Engineers Comments Regarding Surface Water Drainage

Application Reference:	M/39/24/DOC	Reviewer Reference:	ADC/PC
Planning Officer:	Kathryn Welch	Date of Review:	28/11/2025
Site Name:	117 Elmer Road Middleton-on-Sea PO22 6LH		
Application Description:	Approval of details reserved by condition imposed under reference M/84/23/PL relating to condition number 7 - surface water drainage scheme.		
Assessment Number:	1 of 2

Surface Water Drainage Report - Sept 2025 MC0539 Naldrett Elmer Road DOC Rev P2

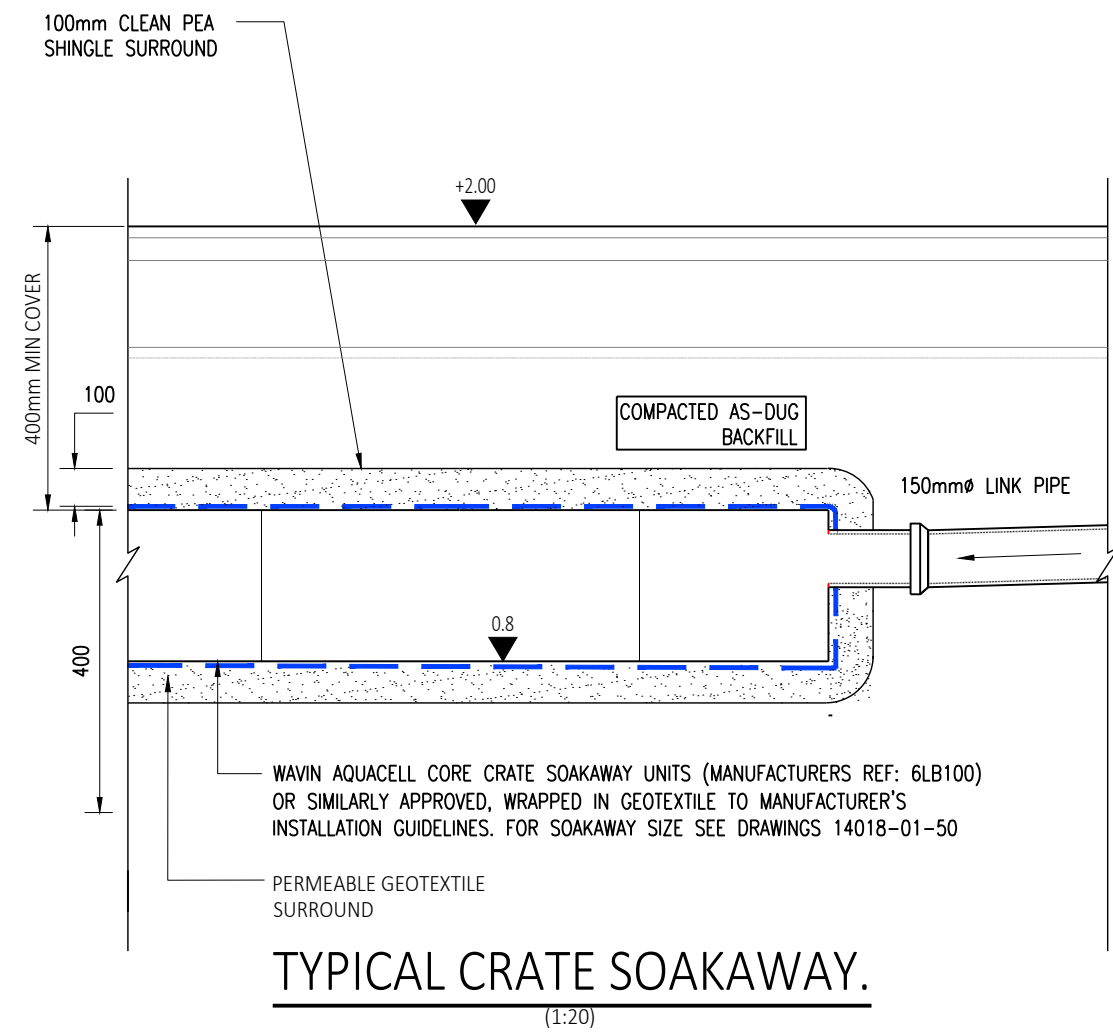
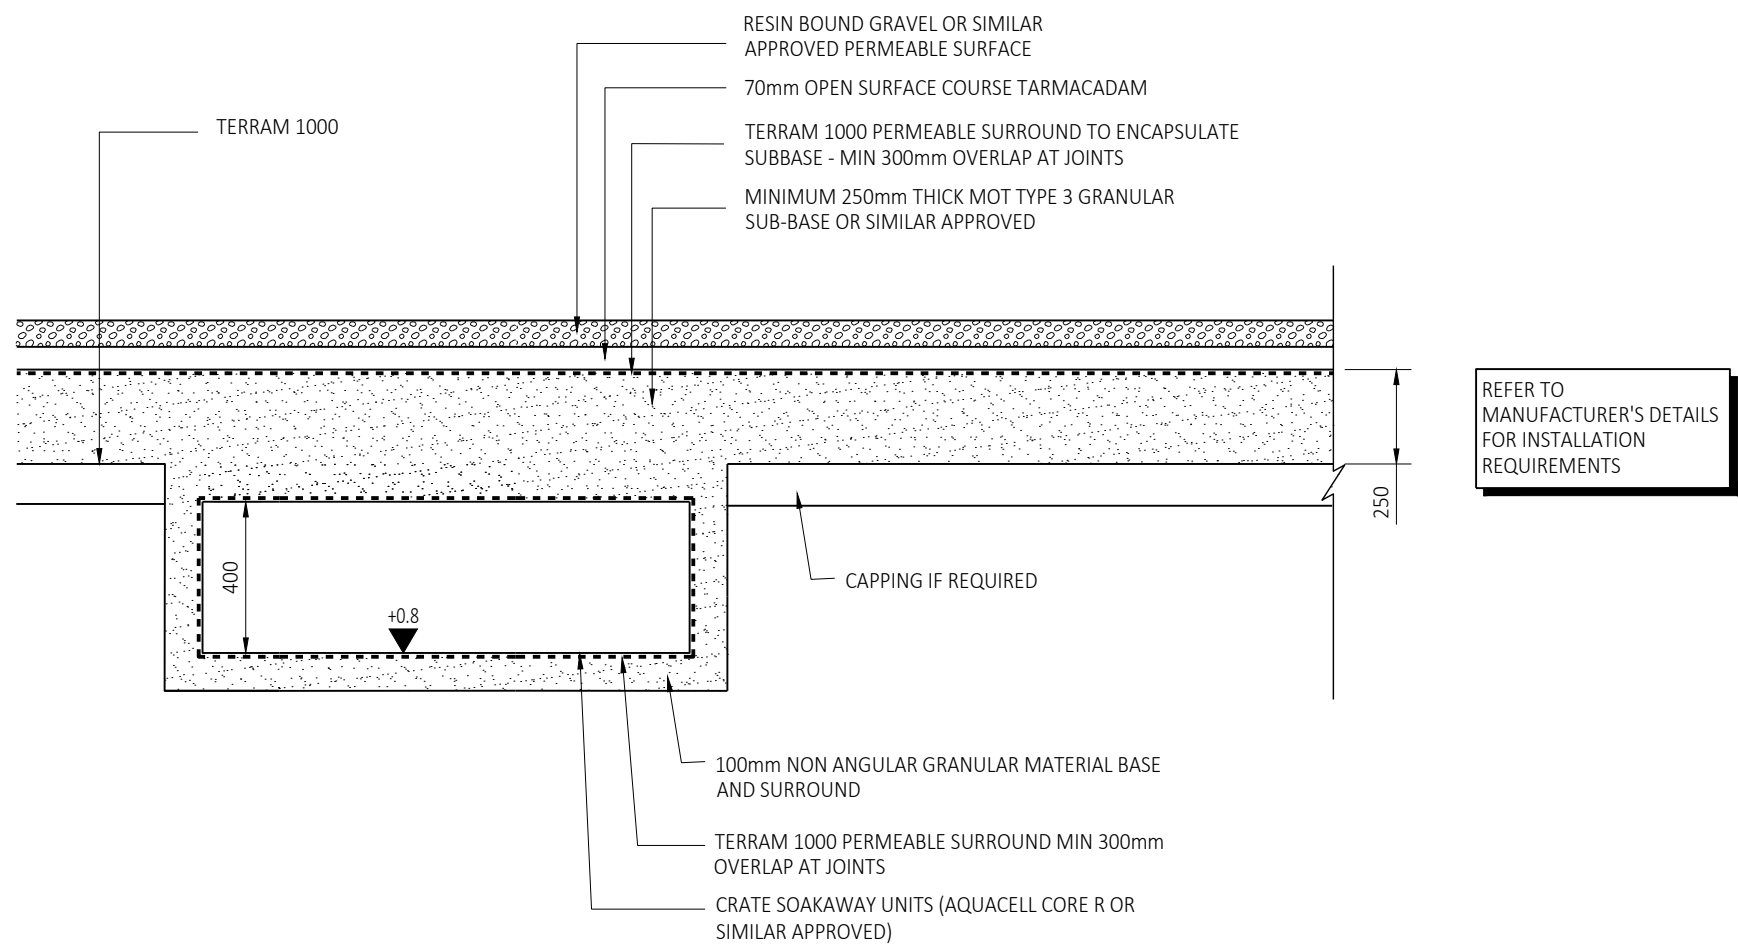
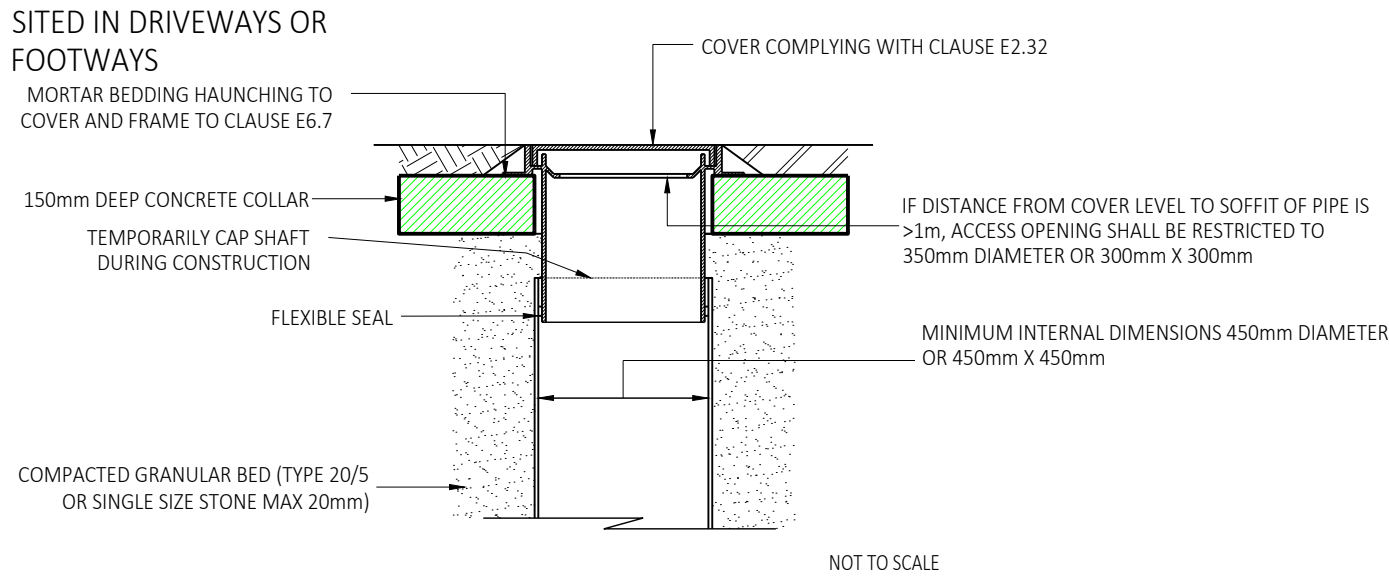
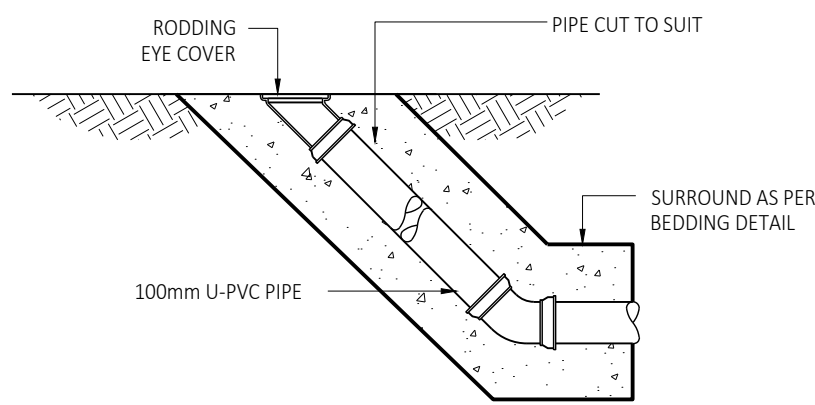
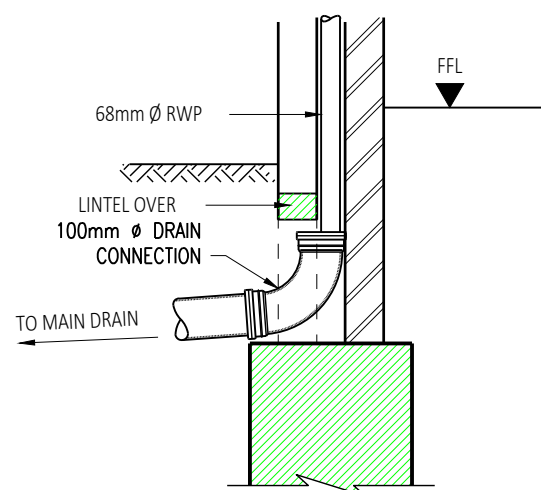
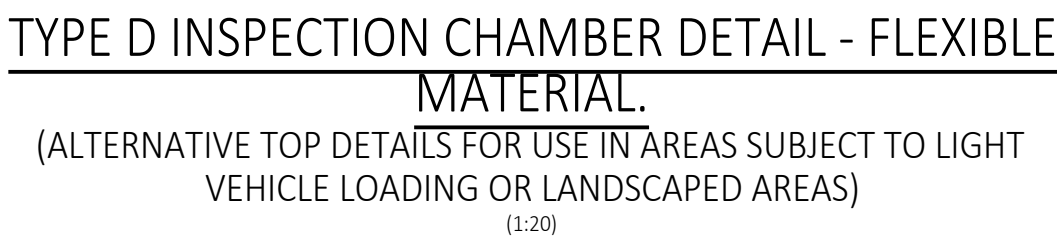
rate at the proposed depth of the now formal permeable paving construction. If provided, please provide a construction detail drawing, to include base level of diffuser, and invert level at the point of connection of the catchpit.			
24.				Climate change allowance for the 1% AEP event must be 45%.	Ok. Point closed.		
25.				Please provide 10% + CCA and 3.33% AEP + CCA calculations.	Ok. Point closed.		
26.				Please specify catch pit diameter.	Ok. Point closed.		
27.				Typical crate soakaway refers to a slotted pipe, it is not clear why. Please adjust.	Ok. Point closed.		
28.				Rodding eye detail, the pipe diameter needs to	Ok. Point closed.

be corrected to 100mm in accordance with the design.			
29.				The design infiltration rate has been applied to the base and the sides of the soakaways and permeable paving in the calculations. Please apply to the base OR the sides, not both. The design infiltration rate must be 0.02952m/hr or 8.2×10^{-6}m/s (as per point 1).	Now applied to base only. Point closed.		
30.				Please provide construction detail for oblique pipe to pipe connections/junctions.	Please remove the 90 degree option from construction detail, as 45 degrees provides better hydraulics.	A saddle connection construction detail has now been provided instead. This is not acceptable for pipes of the specified diameter. Please revert to the junction type connection but with the 45 degree connection angle	Ok. Comment closed.

cover associated with each bedding type.		
--	--	--	--	--	---	--	--
